Dyddiad / Date: 9 November 2018

**ABERGELLI POWER LIMITED: PROPOSED GAS FIRED POWER PLANT AT LAND ADJACENT TO THE FELINDRE GAS COMPRESSOR STATION AT ABERGELLI FARM, FELINDRE, SWANSEA, SA5 7NN**

**WRITTEN REPRESENTATIONS BY THE NATURAL RESOURCES BODY FOR WALES.**

Figure 2-4 Plan showing nearby drains and watercourse to the site (Central section)

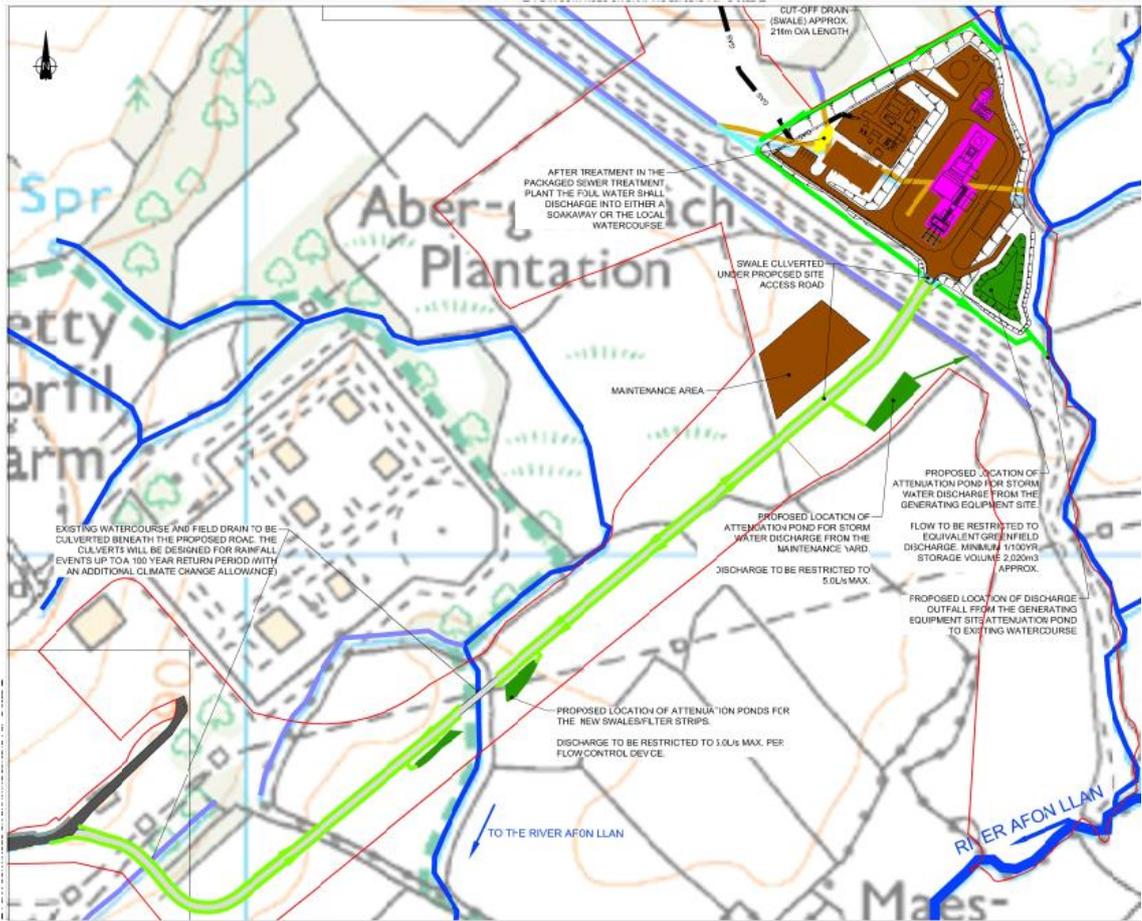
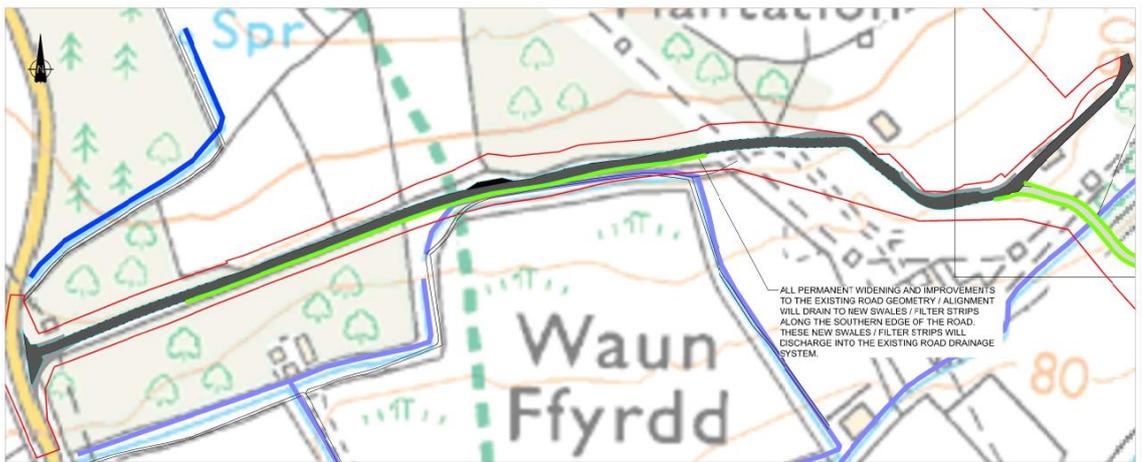
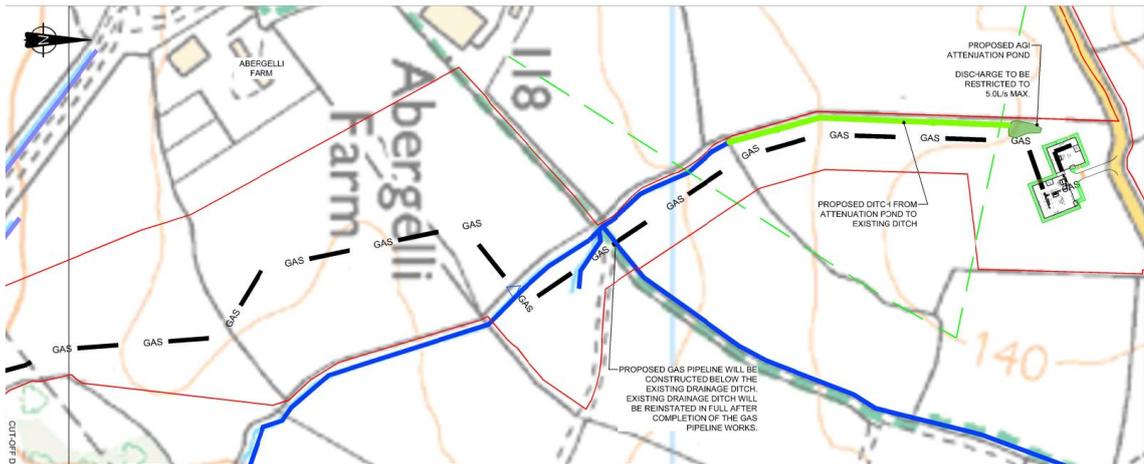
It is currently unclear how these watercourses will be crossed, and this detail does not appear to have been included within the Outline Drainage Strategy. Details on any culverting and re-routing of watercourses, and riparian habitat retention/reinstatement will be required, as well as the measures that will be put in place to ensure that protected species can continue to move along the watercourses. These should be provided within the appropriate DCO Requirements.
